Y/146/20/RES

Land at Street Buildings North End Road Yapton BN18 0DT

Application for approval of reserved matters for the erection of 45 dwellings pursuant to Section 73 permission Y/13/18/PL (following the grant of outline planning permission Y/49/17/OUT) (resubmission following Y/39/20/RES). This application may affect the setting of a Listed Building

Title:
PLANNING LAYOUT

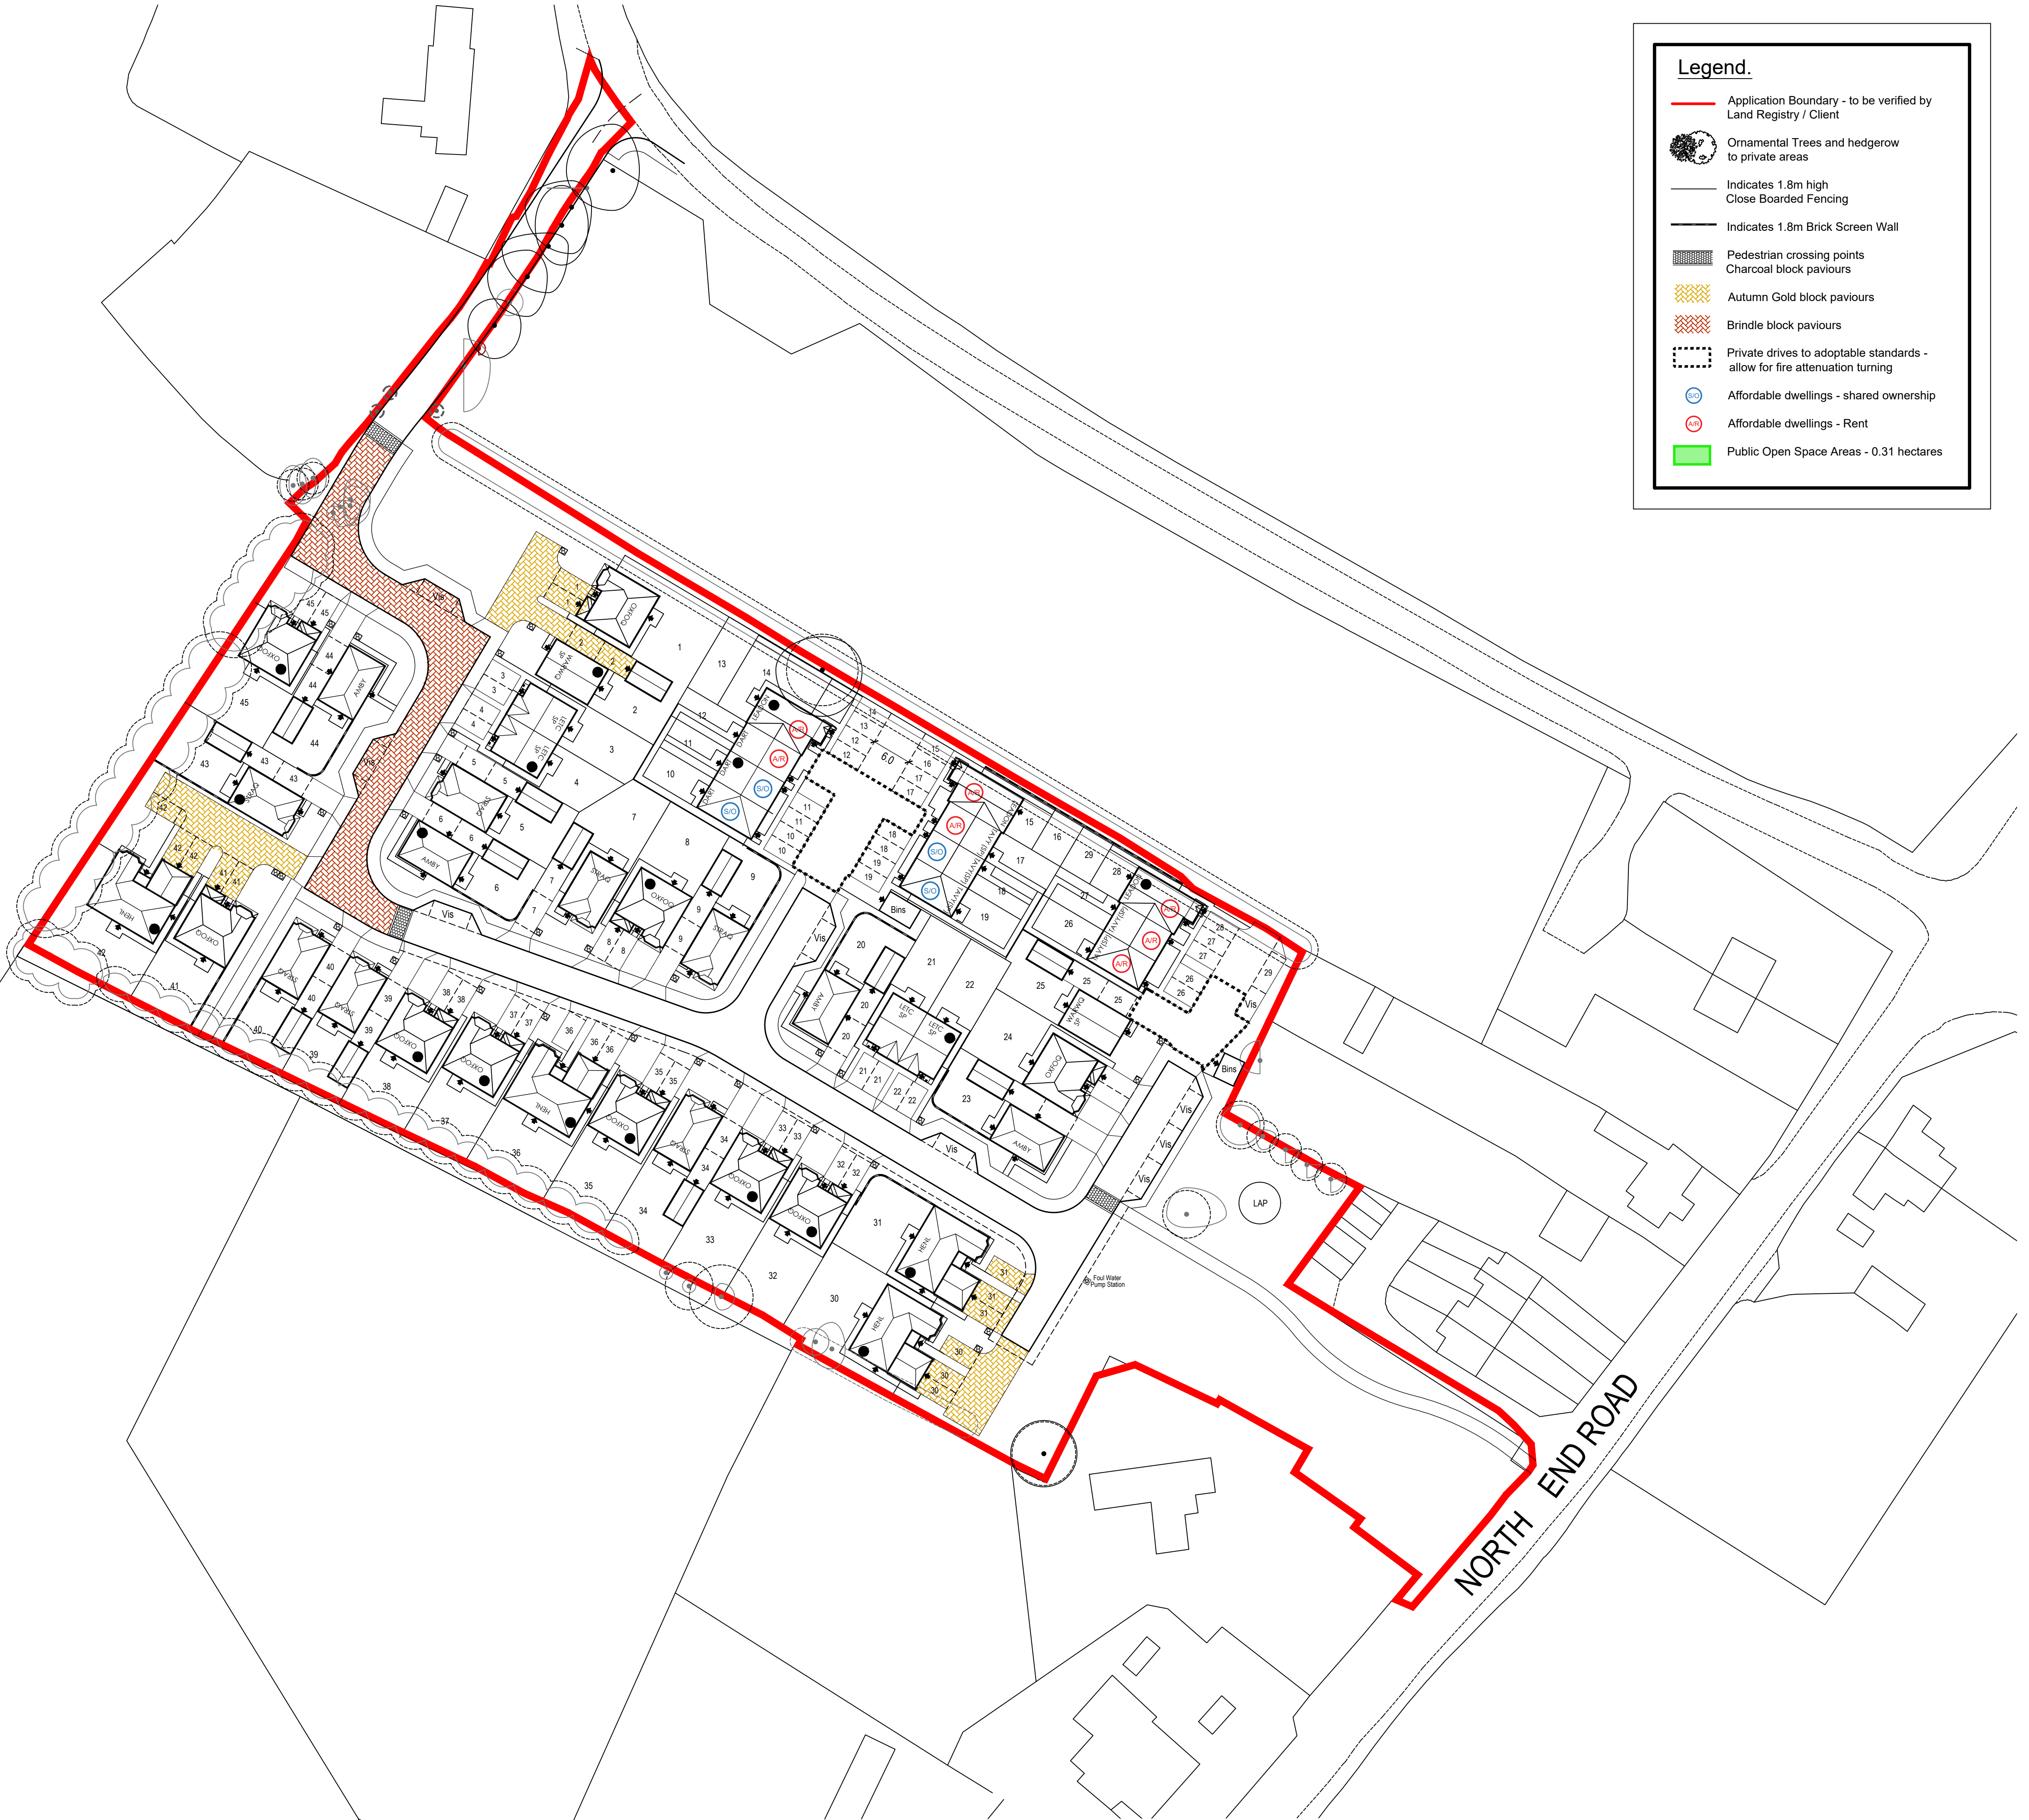
contains a flint and brick barn, which it would seem is to be demolished. This is unfortunate as it forms part of the character of the area.

The proposal relates to 45 new houses and associated landscaping. It would appear that the site has been organised so that the new houses are set back from North End Road with the closest buildings being located to the rear of the curtilage of the assets identified above.

I note in the Design and Access Statement that it identifies that the existing flint wall to North End Road will be retained, if possible, and extended in a sympathetic way. The retention of the wall is a positive feature of the proposal and any works to extend it should be carefully implemented in order to ensure that it closely reflects the existing element. If the wall has to be removed, and it is to be replaced, a new flint wall should be provided. Details of any new walling in this location, including materials and appearance could be provided for by way of condition if you are minded to approve it.
